SSD-10436: HORSLEY LOGISTICS PARK | SECTION 4.55(1A) MODIFICATION APPLICATION

This Section 4.55(1A) modification application to SSD-10436 (as modified by Mods 1 to 6) seeks approval for revisions to the approved development of the Horsley Logistics Park (**HLP**) and is herein referenced as Mod 7.

The proposed modification to the HLP seeks to remove Condition B15 which requires the construction of an acoustic barrier on Lot 201. It is noted that following the approved design amendments to Lot 201 within Mod 1 the acoustic wall was made superfluous.

DRAWING TITLE
ESTATE MASTERPLANDRAWING NUMBER
200226 - DA - MS-A010**2 Location Plan**

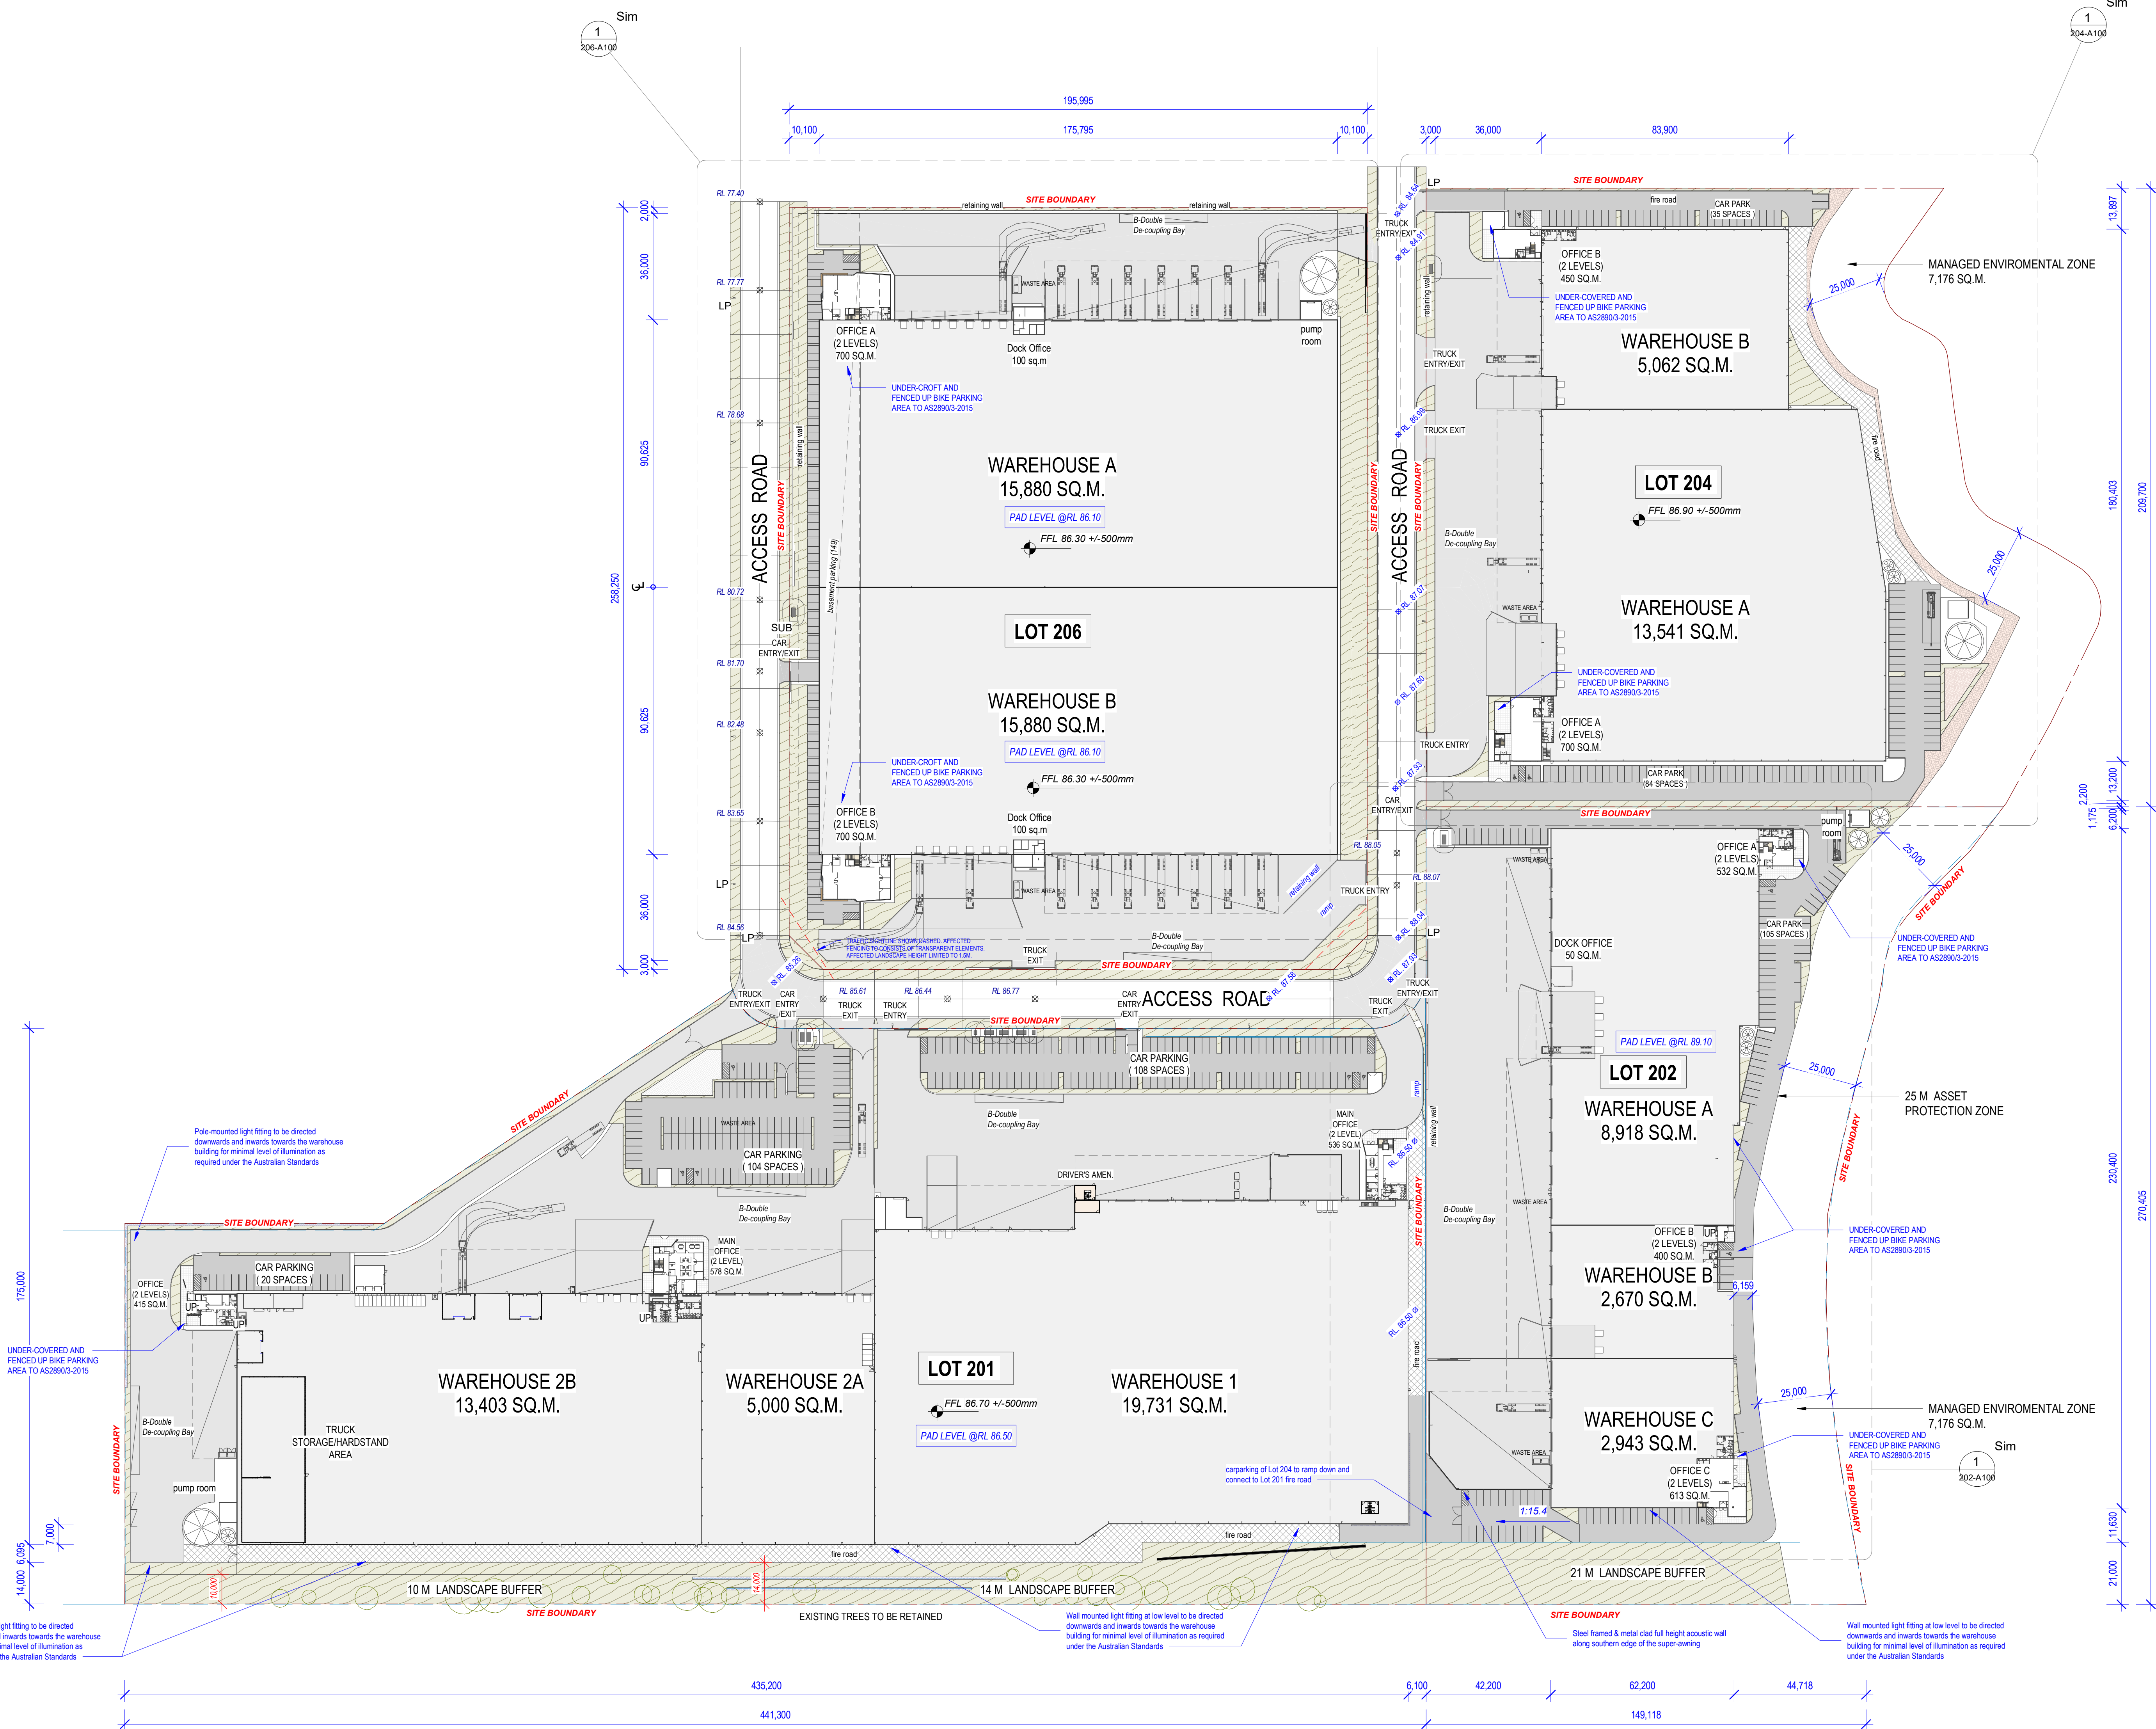
The proposed modification will see amendments to Appendix 1 – Development Layout Plans of Development Consent SSD-10436 to facilitate the revisions to the architectural plans to remove reference to the acoustic barrier. These modifications are detailed in **Section 4.2** of this report.

- Delete and replace the figures in Appendix 1 with the following:

Figure 1: Site Plan – Replace with Drawing No. 200226-DA-MS-A010, Issue P15, 27.07.2022

Figure 6 | 4 m wide area of Southern Landscape Buffer within Lot 201

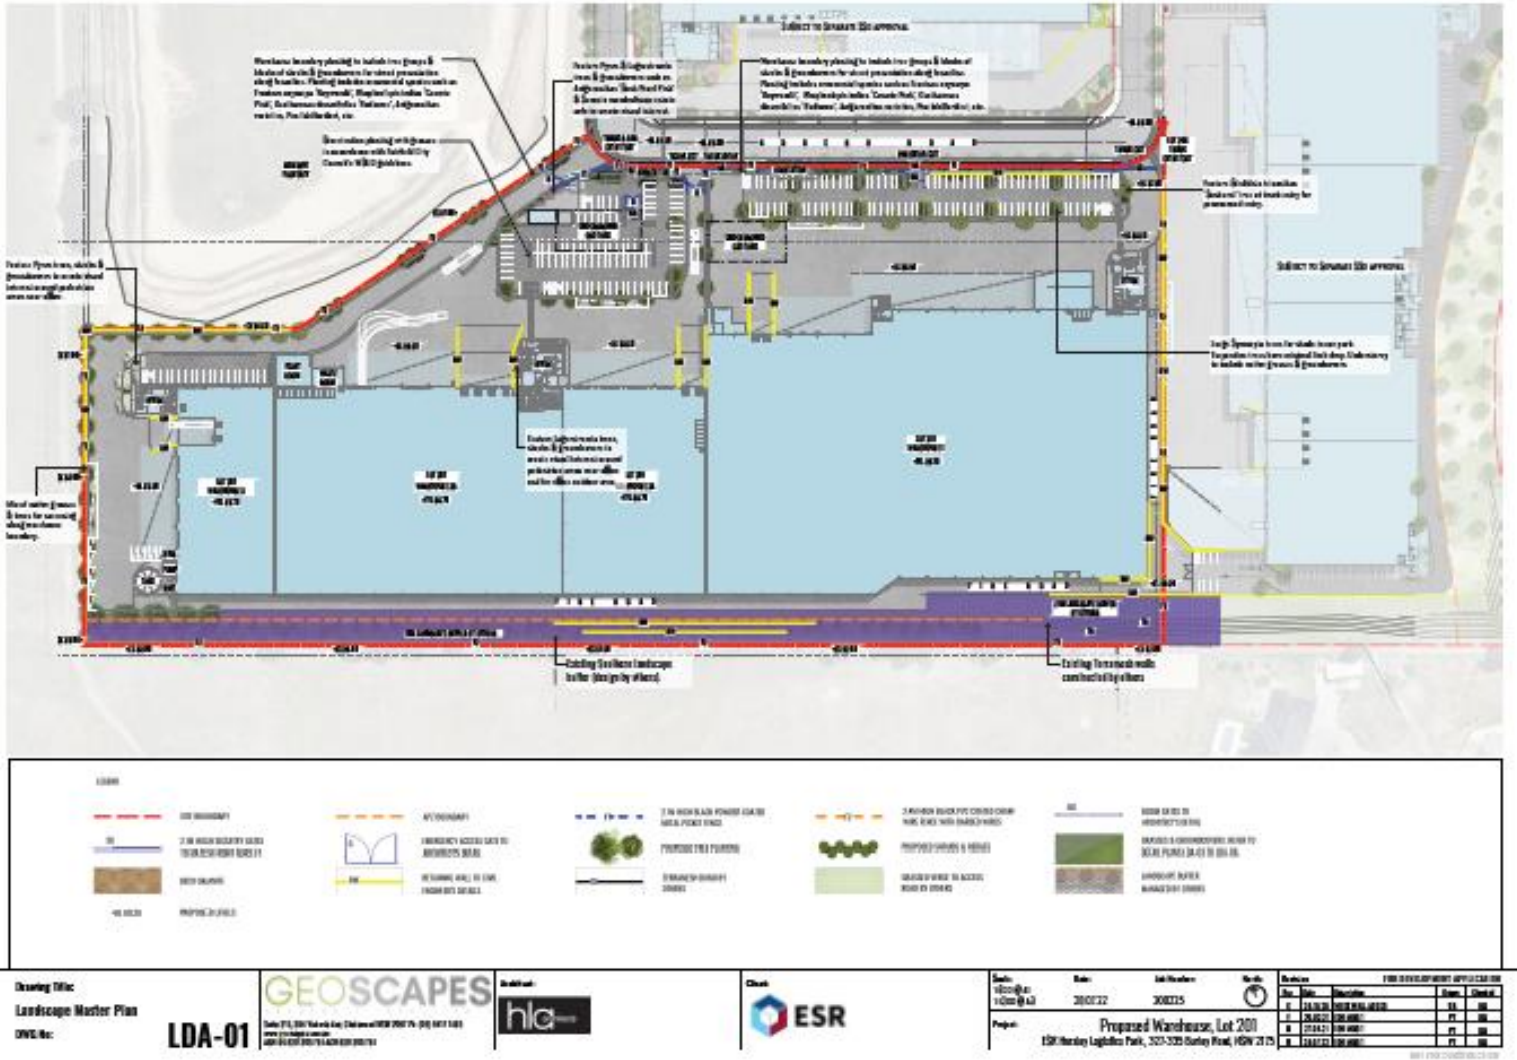
Figure 6: 4 m Wide Area of Southern Landscape Buffer within Lot 201 – Replace with Drawing No. 200225, Rev H, 28.07.2022
